2023/1033

Variation of condition 2 of application 2020/1473 (Erection of 5no. dwellings) to allow for changes in house design of plots 1 and 5

Land to the rear of Lesmond Crescent, Middlecliffe, Barnsley, S72 0EZ

Drawing Title **PROPOSED ELEVATIONS 1 & 5**

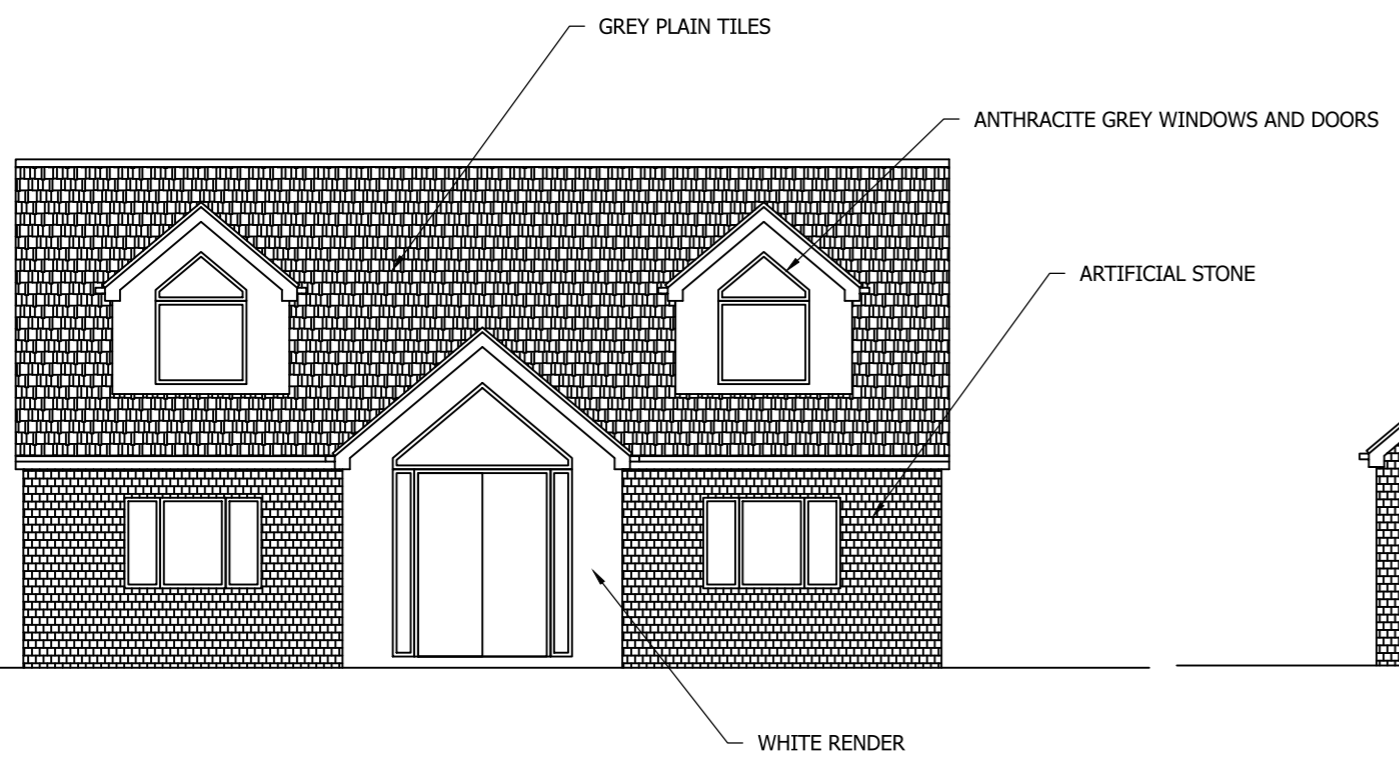
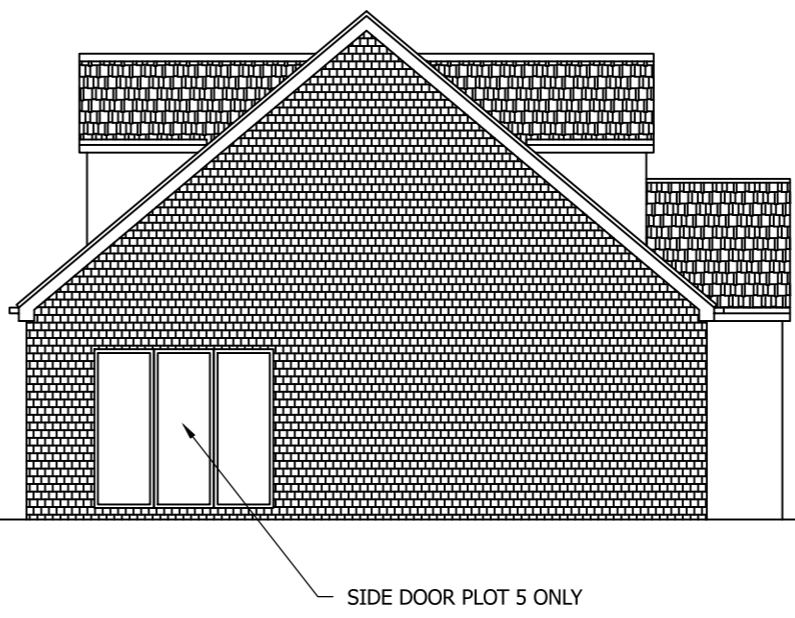
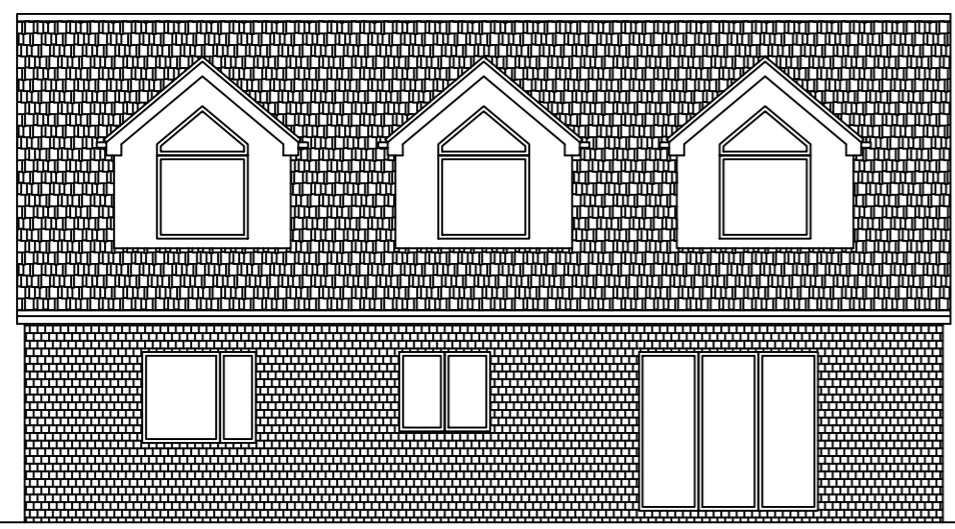
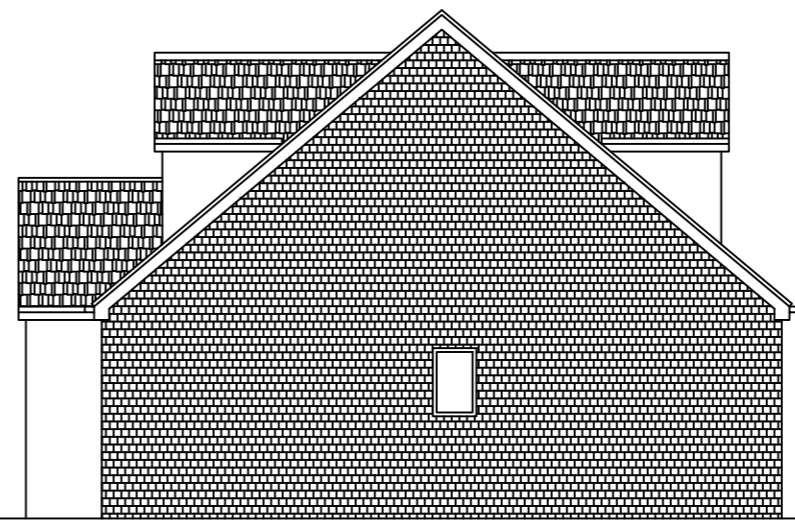
The alteration to the approved plans involve the changes in house design of plots 1 and 5. The changes include the change from hipped roof bungalows to pitched roof dormer bungalows, with rooms in the roof space. The properties have been designed with two dormer windows to the front elevation and 3 dormer windows to the rear.

The design and proposed materials are in keeping with the area which is largely characterised by brick houses and bungalows with some render. Middlecliffe consists of a variety of different designed dwellings, with bungalows and two storey properties, some with hipped and pitched rooflines and dormer windows with flat and pitched roofs feature within the street scene. The proposed bungalows would fit in with the adjacent dwellings, and whilst there are no dormers in the immediate street scene, dormer windows can be seen on properties within the area, in particular properties set on Rotherham Road, some of which back onto the site.

Within the development the separation distances between existing buildings and their private rear gardens to the development meet the standards required by the SPD, with the exception of plot 5 where the new first floor habitable room windows are approx. 9.3m from the rear boundary with the properties along Rotherham Road. Whilst this falls short of the recommended 10m distance to any rear garden boundary, the 0.7m is not a significant distance given that the gardens to the properties along Rotherham Road are approx. 40m in length, therefore there should not be any significant loss of privacy to these gardens. The separation from the new first floor windows to the habitable room windows of the adjacent properties of both plots also exceed the required 21m.

Drawing Title **PROPOSED PLANS 1 & 5**

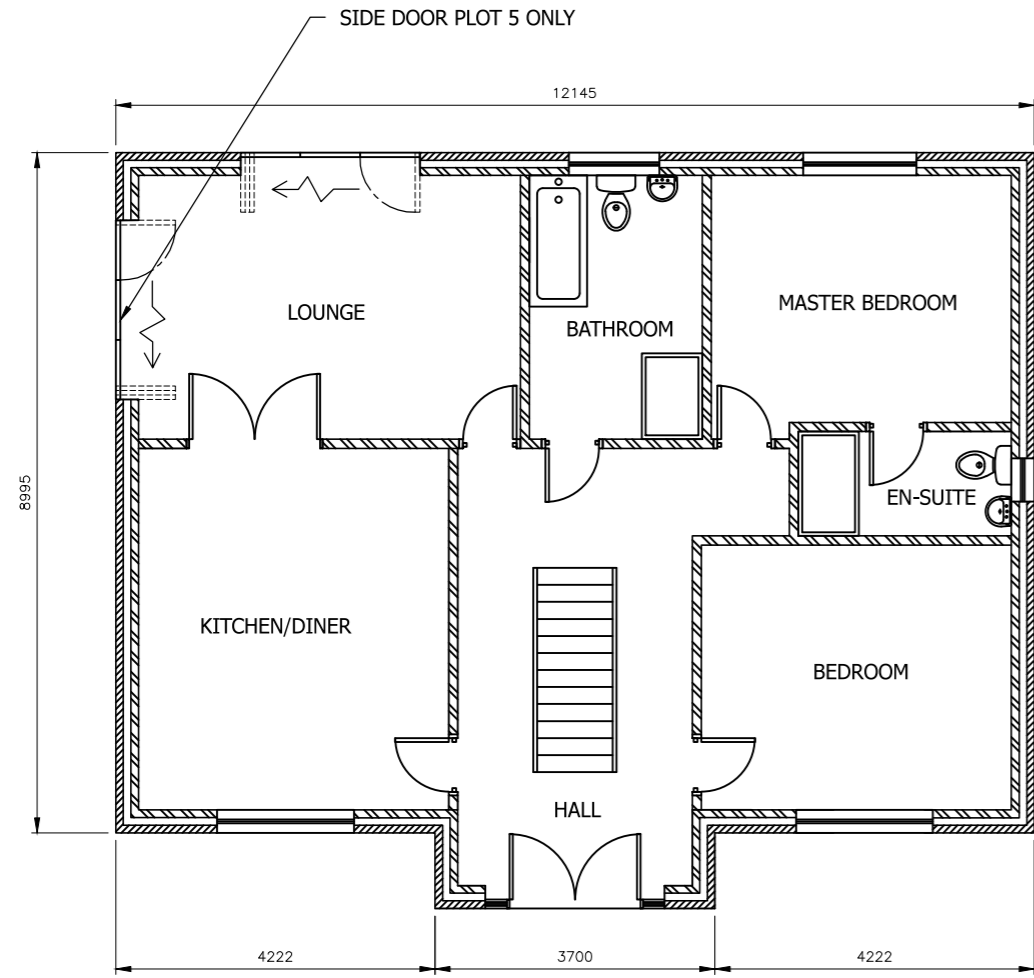
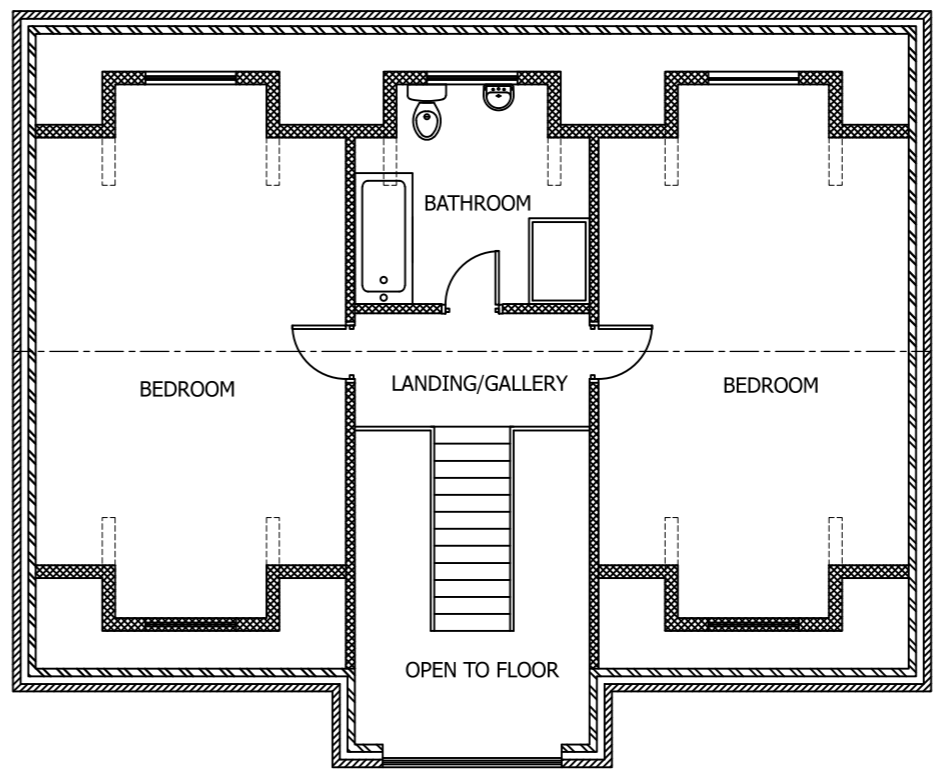
Internally the proposed dwellings provide sufficient space to meet the spacing standards as set out by the South Yorkshire Residential Design Guide and all the plots have private gardens which also meet design guidance in the Design of Housing Development SPD.

Drawing Title
BLOCK PLAN OF SITE

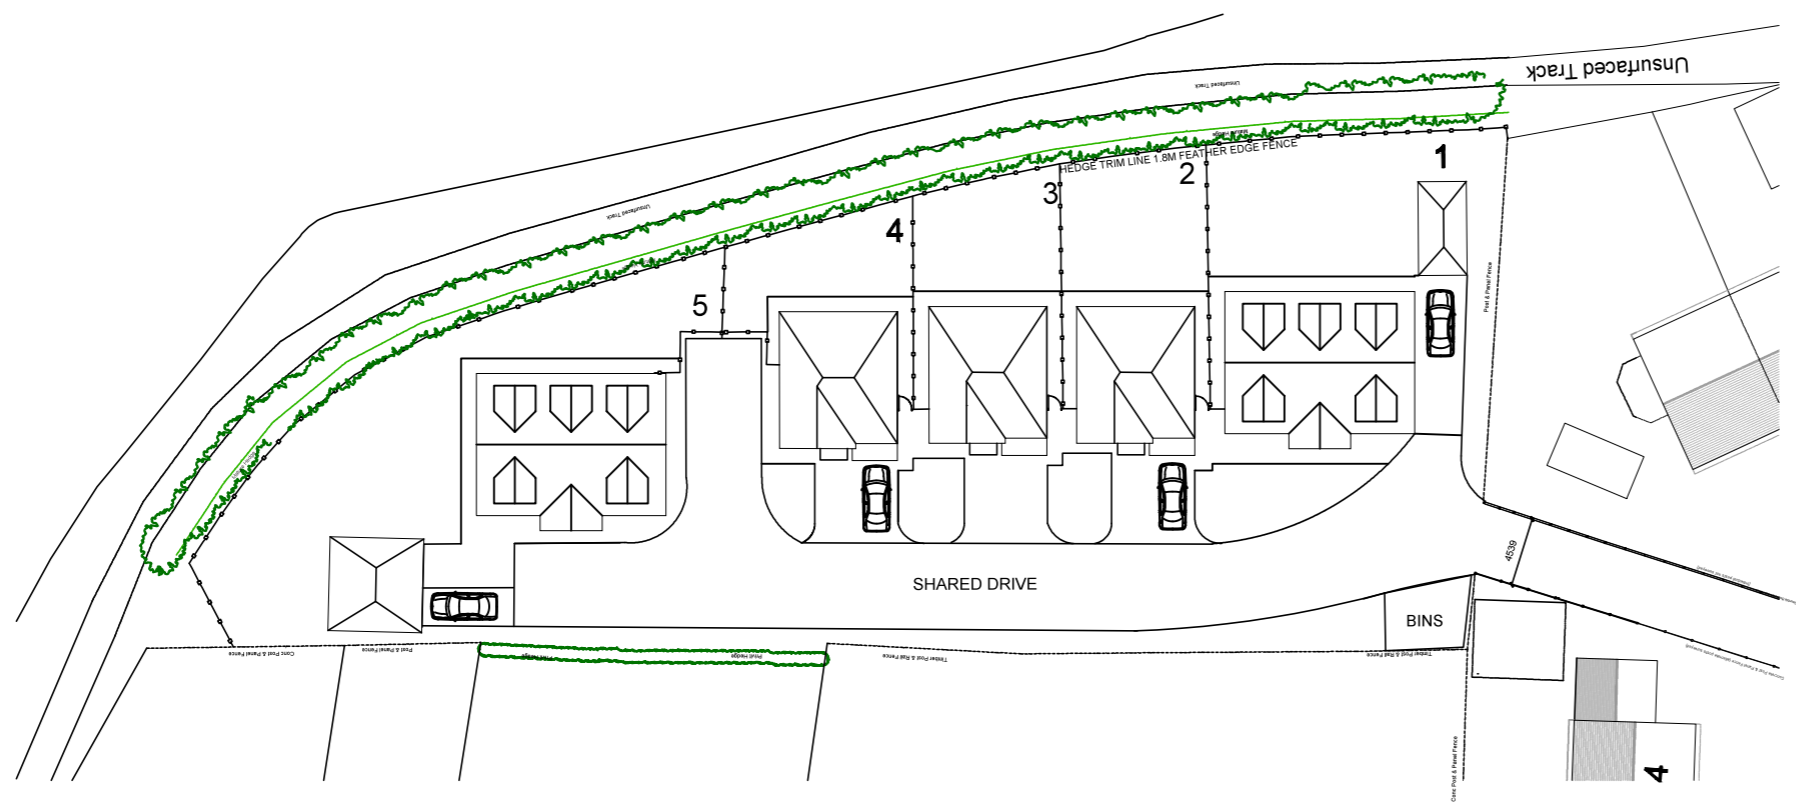
There are no changes to the site layout with the exception of the changes to the plots 1 and 5 from bungalows to dormer bungalows. There is an existing culverted watercourse running through the site along the northern edge which is thought to be from some former mine workings. The culvert has been identified on the site layout plan and can be protected by a condition requiring a 3m easement.
